September 8, 2023

Re: **ALLSUPS #102460**
Project #: PR-2021-006208
Application #: SI-2023-01171

Please find the following responses addressing comments received in a letter dated August 1, 2023. In an effort to address your comments concisely and simplify your review of these development plans, we have summarized your comments and our responses below. Your comment is listed first, followed by the response in Bold.

**A7** SCALE NOT TO SCALE  
**SOLID WASTE ENCLOSURE DETAIL**

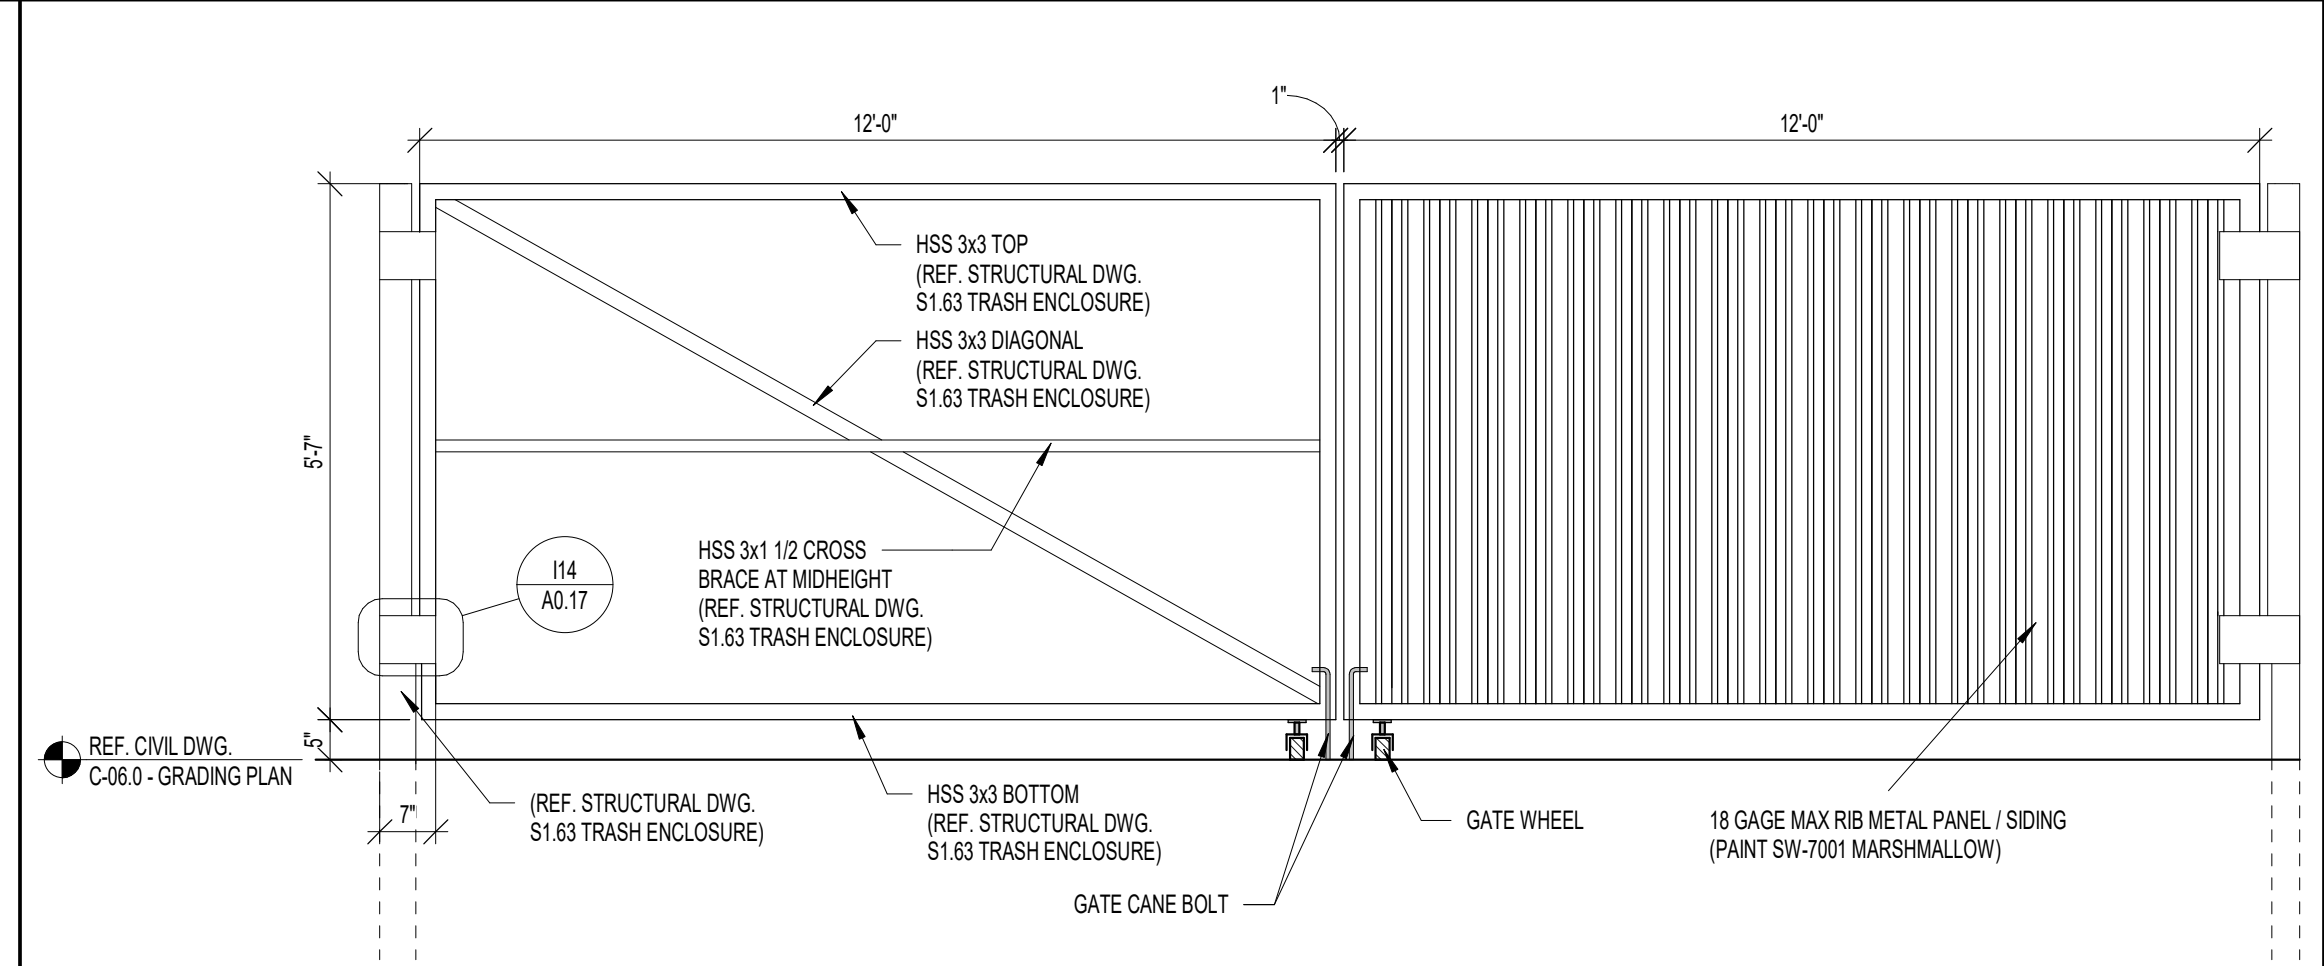
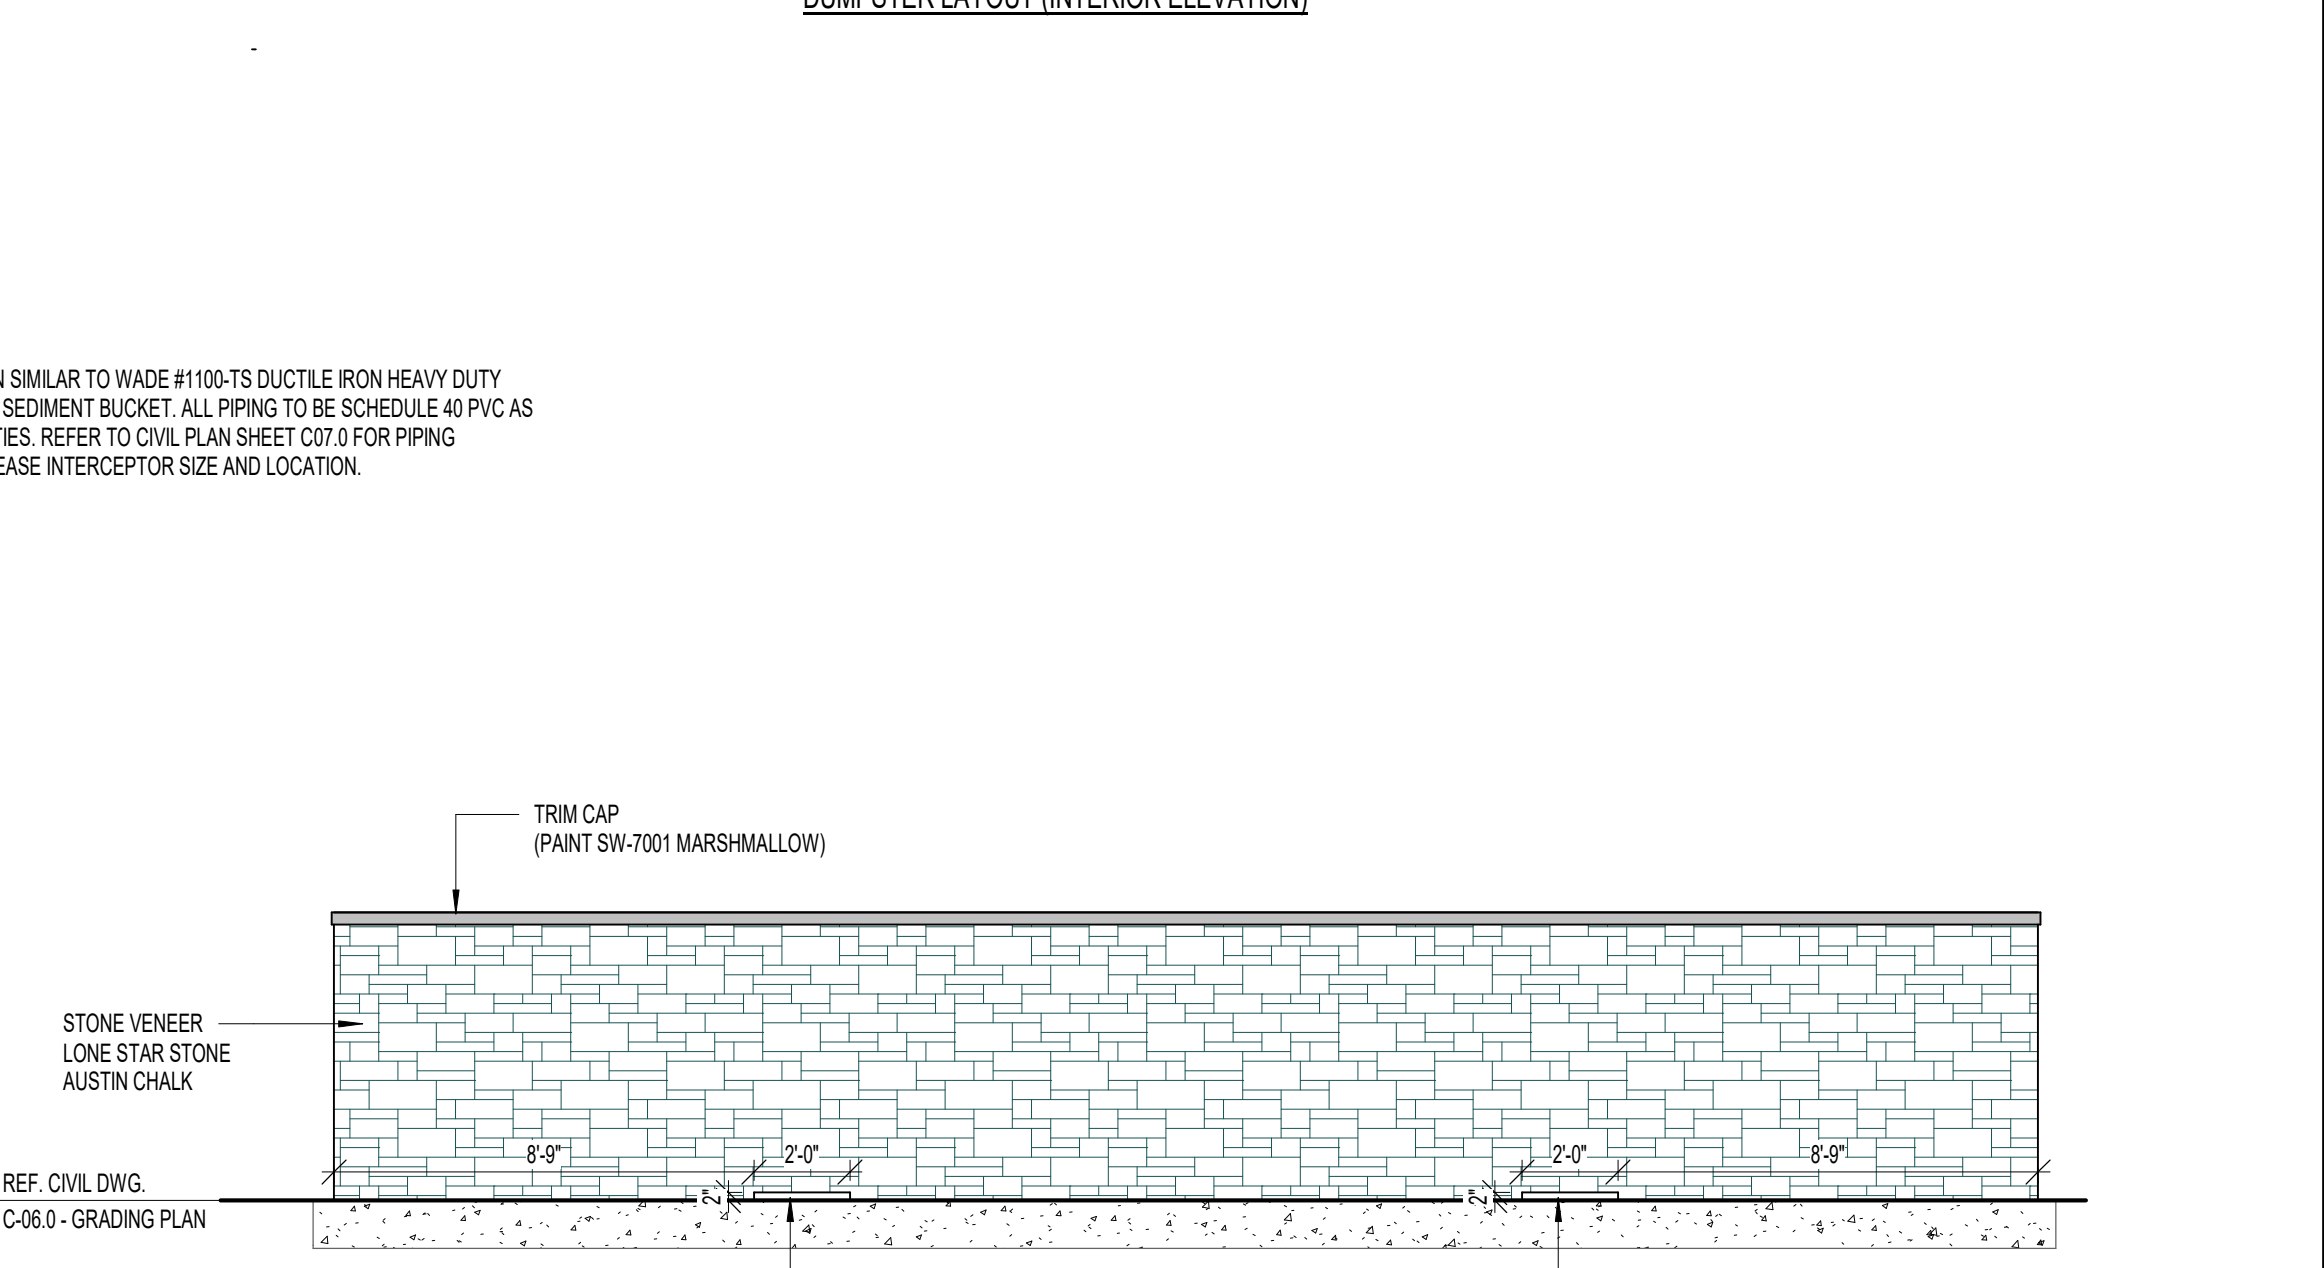
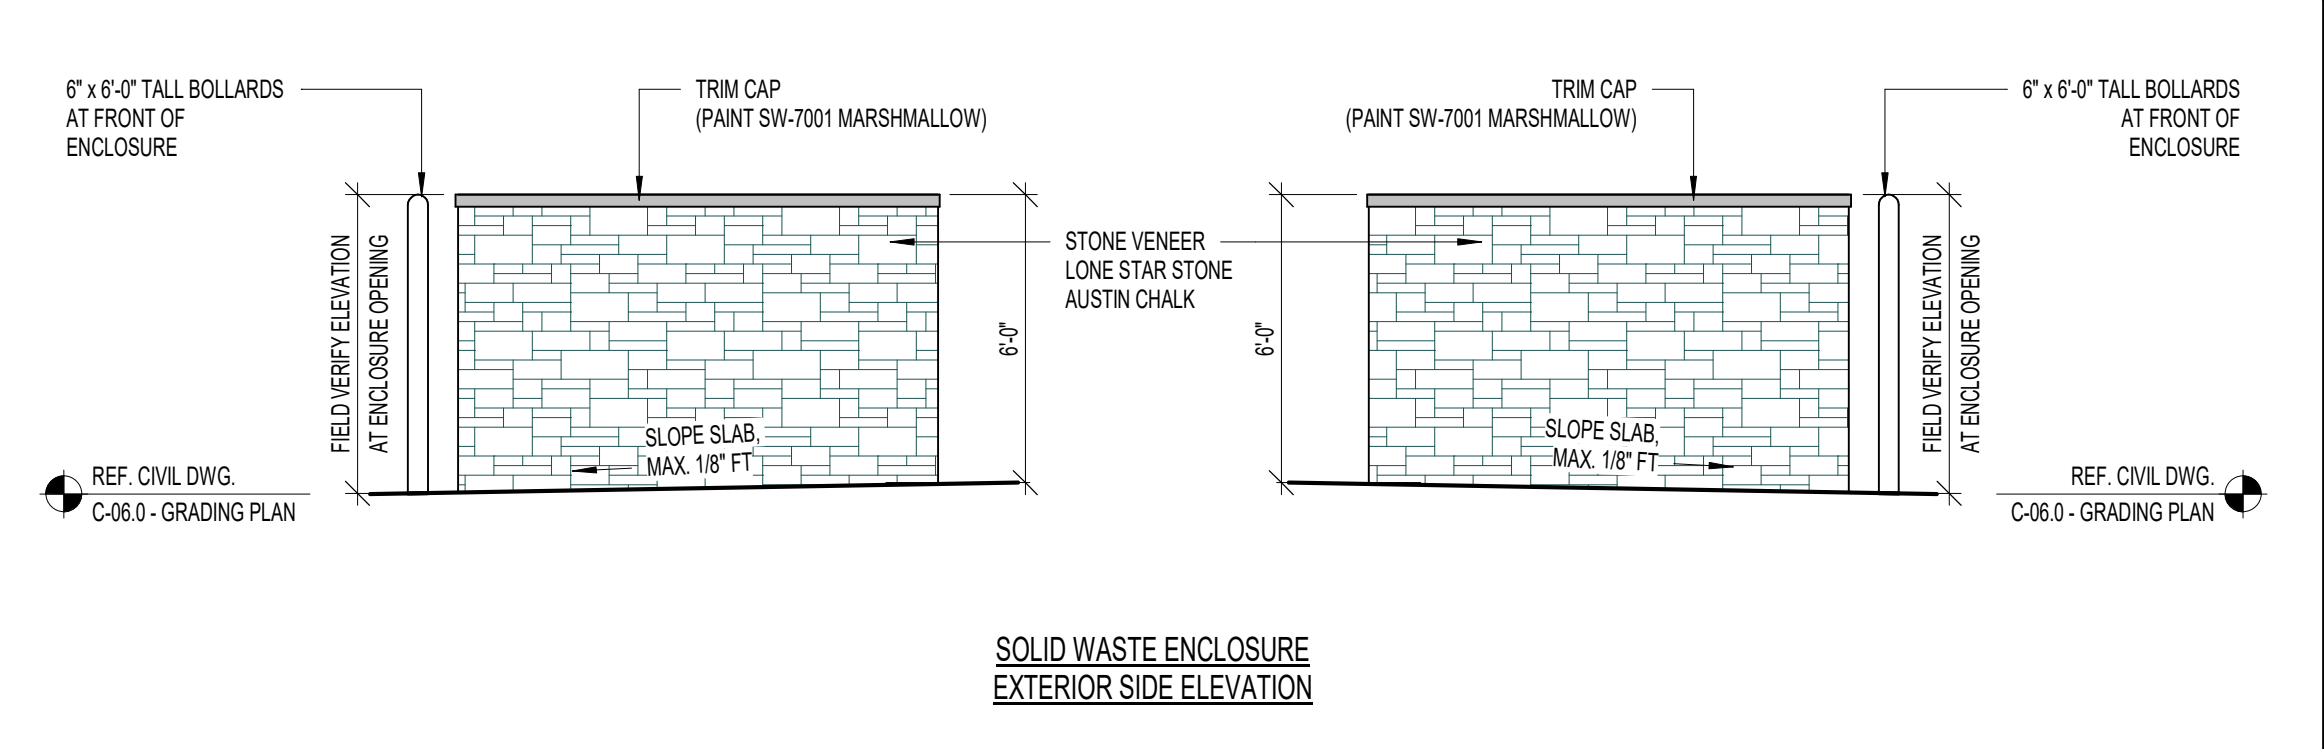
Comment 2: Trash enclosure must include at least one of the primary materials and colors of the nearest wall of the primary building, as per IDO 5-6(G)(3)(e) – appears to be entirely metal panel siding.

Response 2: Trash enclosure updated to include external stone veneer as utilized on building exterior. See sheet A0.17.
